To: All Staff
From: Environmental Health
Date: 2/05/2026
Subject: BL-26-00001

TO: All Staff
FROM: Public Works Plan Review Team
DATE: February 12, 2026
SUBJECT: BL-26-00001 Fields

RECORD OF SURVEY

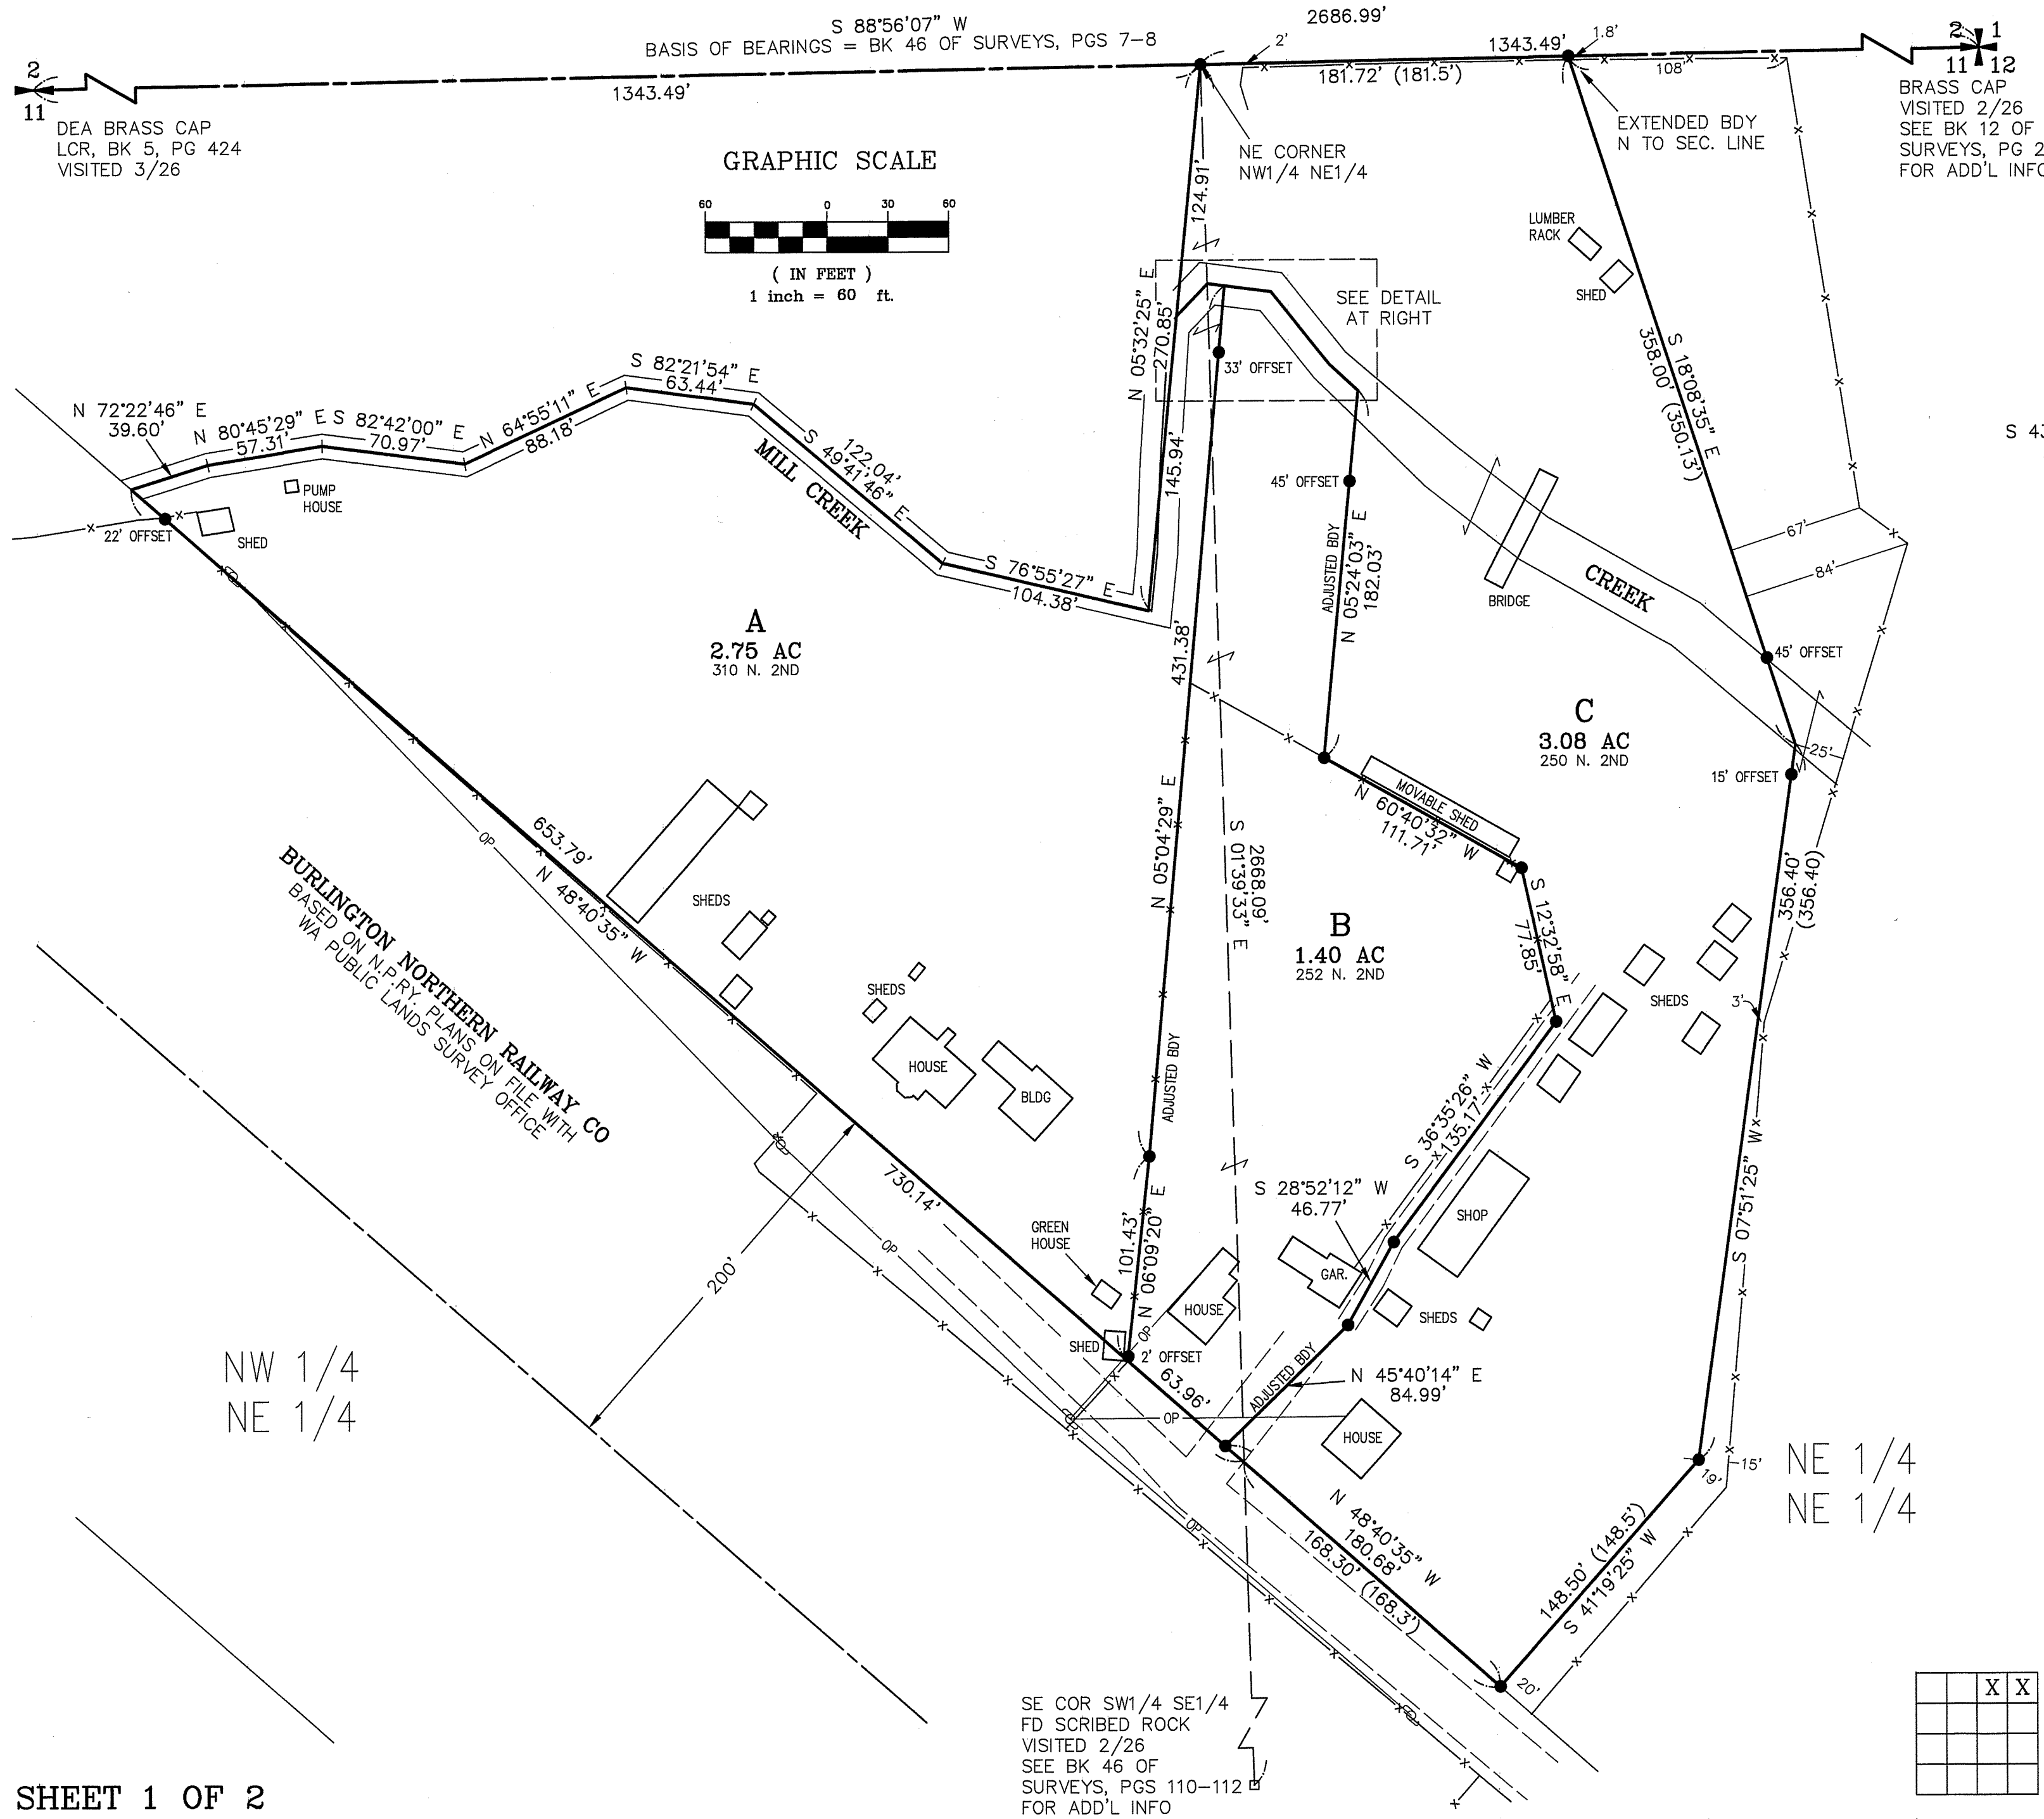
Drinking Water	<ul style="list-style-type: none">• No Comment
Wastewater	<ul style="list-style-type: none">• KCPHD recommends maintaining property line / easement setbacks of five feet from new and existing septic systems shown in WAC 246-272A-0210 Table IV• KCPHD recommends a Site Evaluation be conducted on lot B to verify soil type in regard to minimum land area requirements WAC 246-272A-0320 Table XI

ACCESS	<ol style="list-style-type: none"> 1. An approved access permit shall be required from the Kittitas County Department of Public Works prior to creating any new driveway access or altering an existing access. 2. Maintenance of driveway approaches shall be the responsibility of the owner whose property they serve. The County will not maintain accesses. 3. Any further subdivision or lots to be served by proposed access may result in further access requirements. See Kittitas County Road Standards. 4. Provide proof of easement for shared driveway access to lots prior to final approval. <p>In addition to the above-mentioned conditions, all applicable Kittitas County Road Standards apply to this proposal. Access is not guaranteed to any existing or created parcel on this application</p> <p>OF NOTE: Parcel 745933 to retain address 310 N 2nd St ; It is unclear which home will retain 250 and 252 N 2nd St on parcel 685933.</p>
